SSD-98363228 — Montefiore Seniors Housing Development, 19–25 College Crescent, St Ives

SUBMISSION: Impacts on Alcove, 132–138 and 9-15 Link Road Killeaton Street, St Ives

Attention: Liz James, NSW Department of Planning, Housing and Infrastructure

# Deep Soil

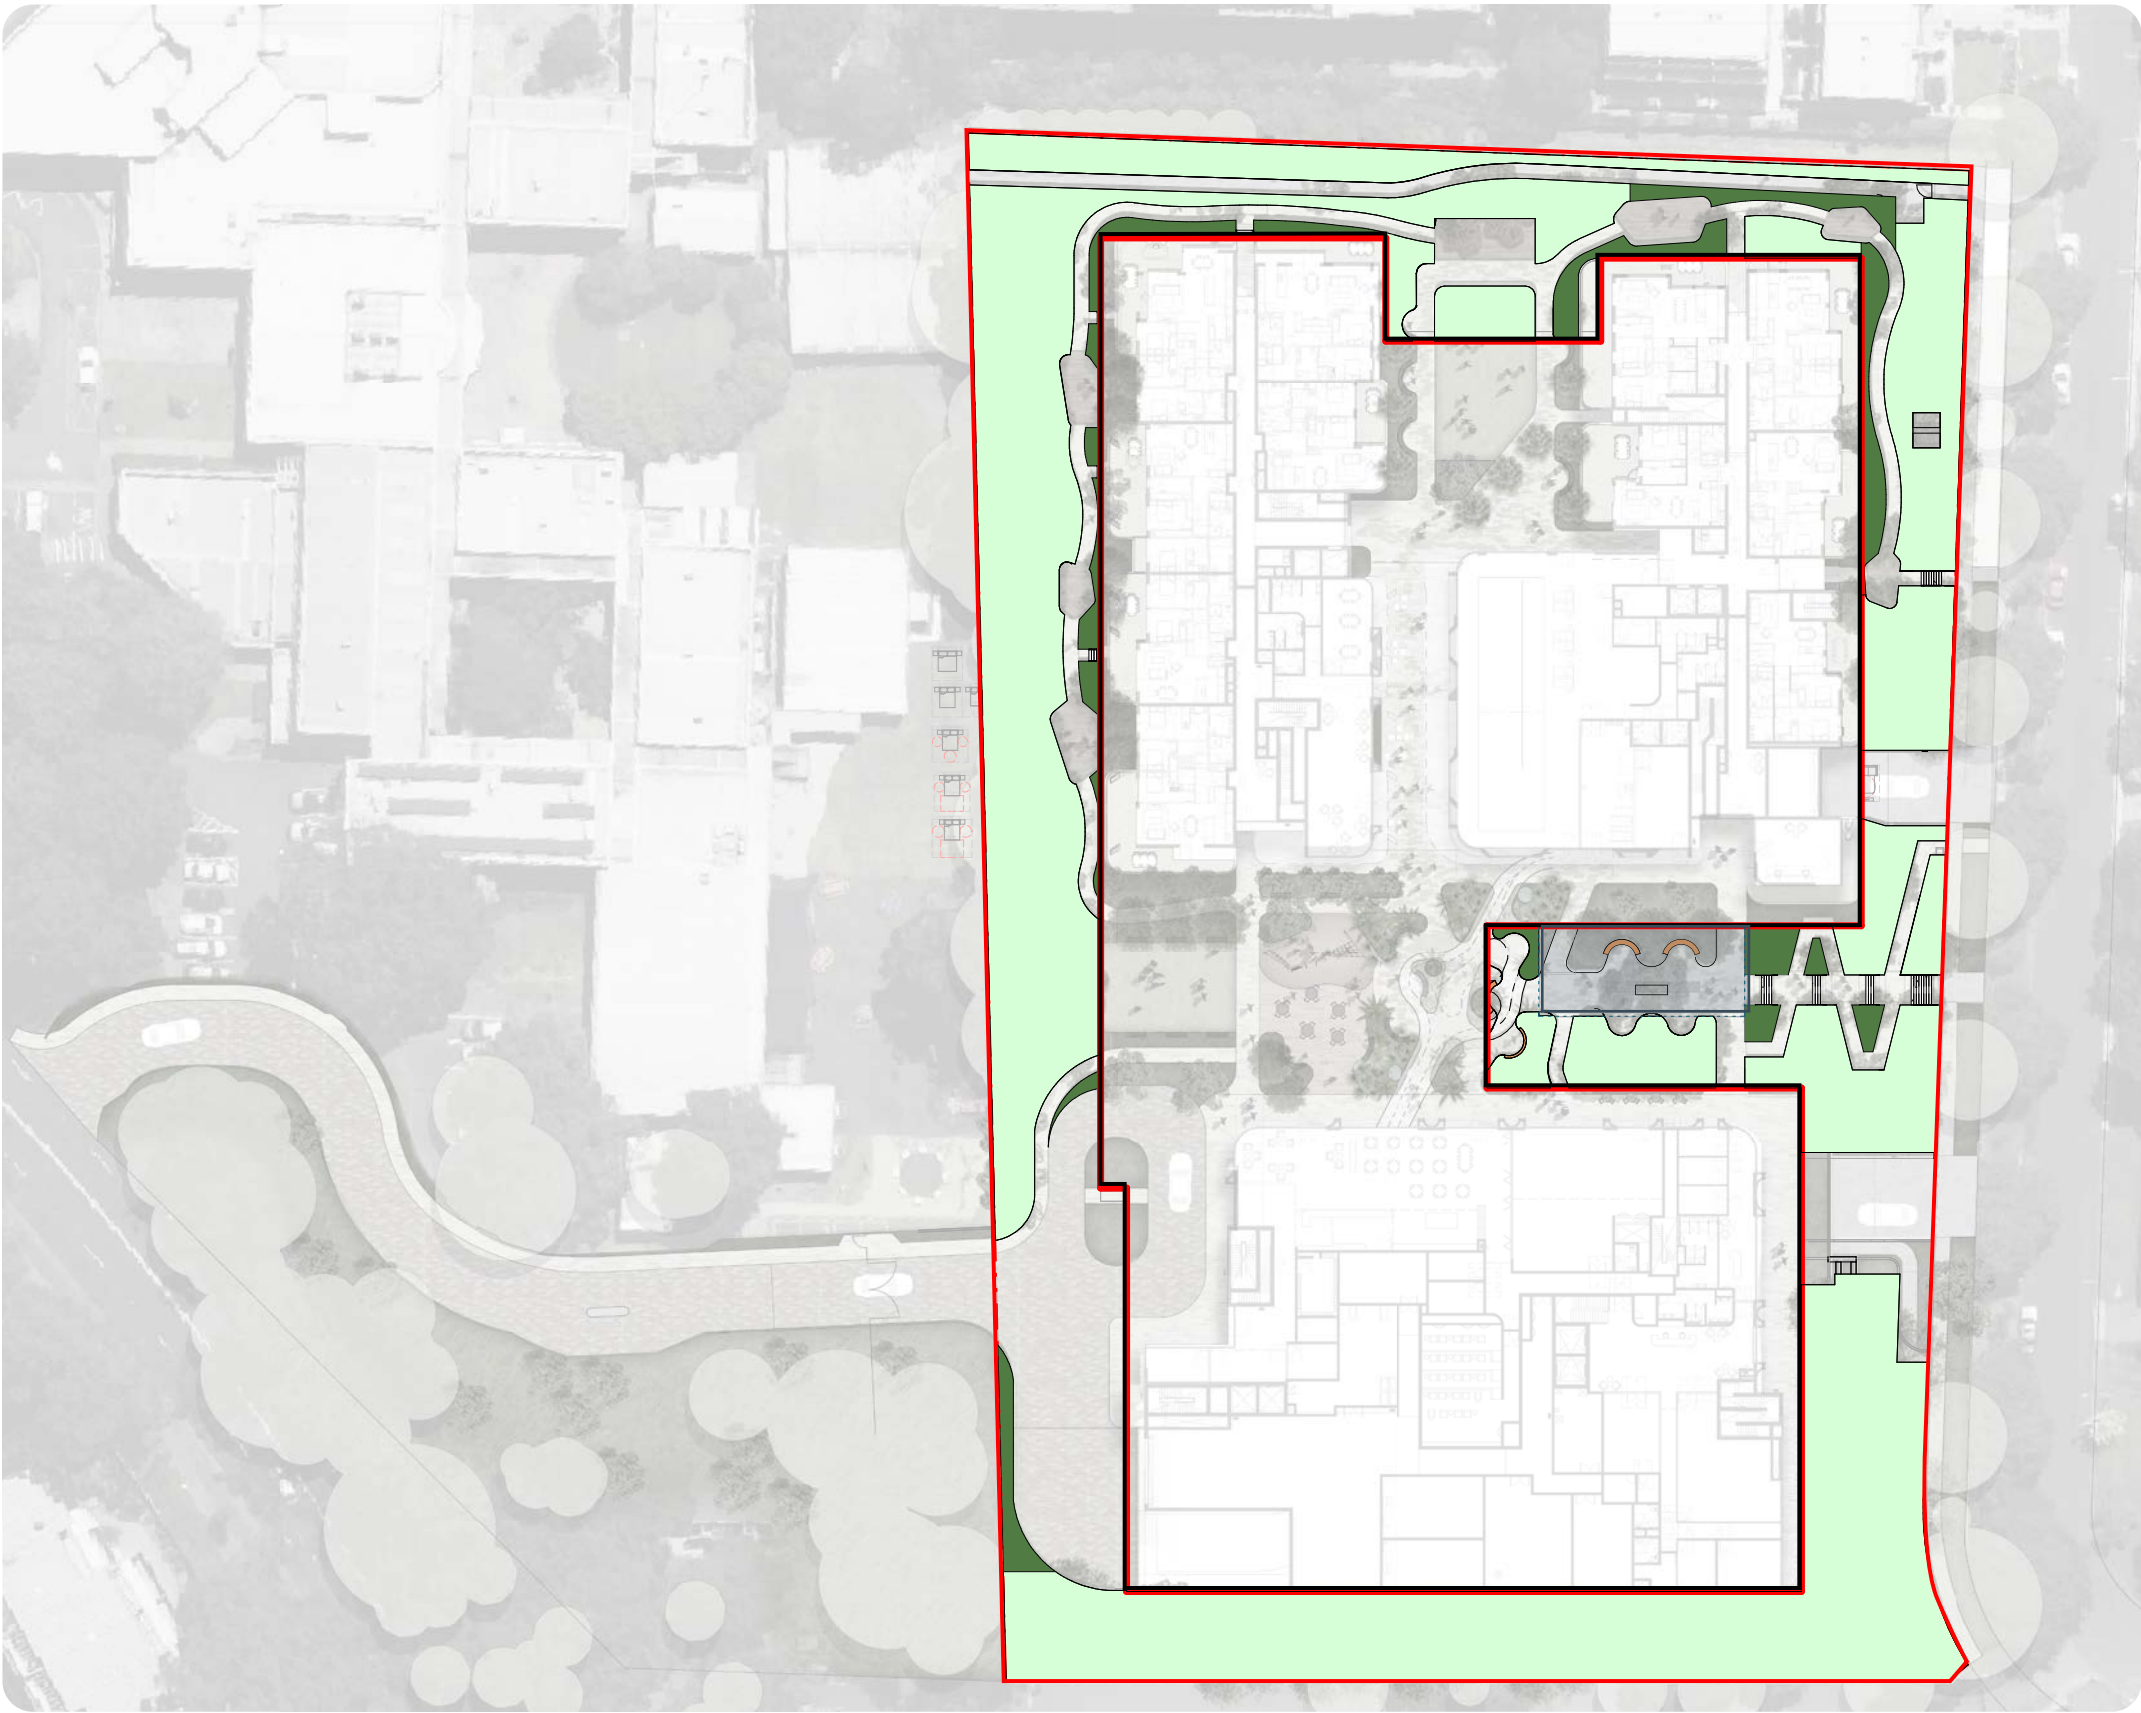
Deep soil planting is essential to soften the visual impact of the proposal and to support biodiversity. The applicant says the site has 24% deep soil (3,435 m² of 14,497 m²), but that number doesn't add up. Deep soil is meant to be genuine unbuilt ground, with nothing above or below it. Both the Housing SEPP and the Apartment Design Guide make that clear: anything on top of a basement, over underground services, or under a driveway or path doesn't count.¹¹ The applicant's own plan shows the basement covering 8,903 m² (61% of the site), leaving only about 5,594 m² of ground that isn't over basement, and once the stormwater tank, rainwater tank, northern services corridor, internal roadway, basement ramps and driveways are taken out, there isn't 3,435 m² of real deep soil left. The ADG also requires each deep soil area on a site over 1,500 m² to be at least 6 metres wide to count, and the plan doesn't show that the narrow green strips along the boundaries meet that width.¹²

- Require the proponent to redraw the deep soil plan to show only genuinely unbuilt above and below areas, to mark the width of each area to confirm the 6-metre minimum.
- Provide plans for the pedestrian school path and assurance that the trees along the common boundary are being retained.
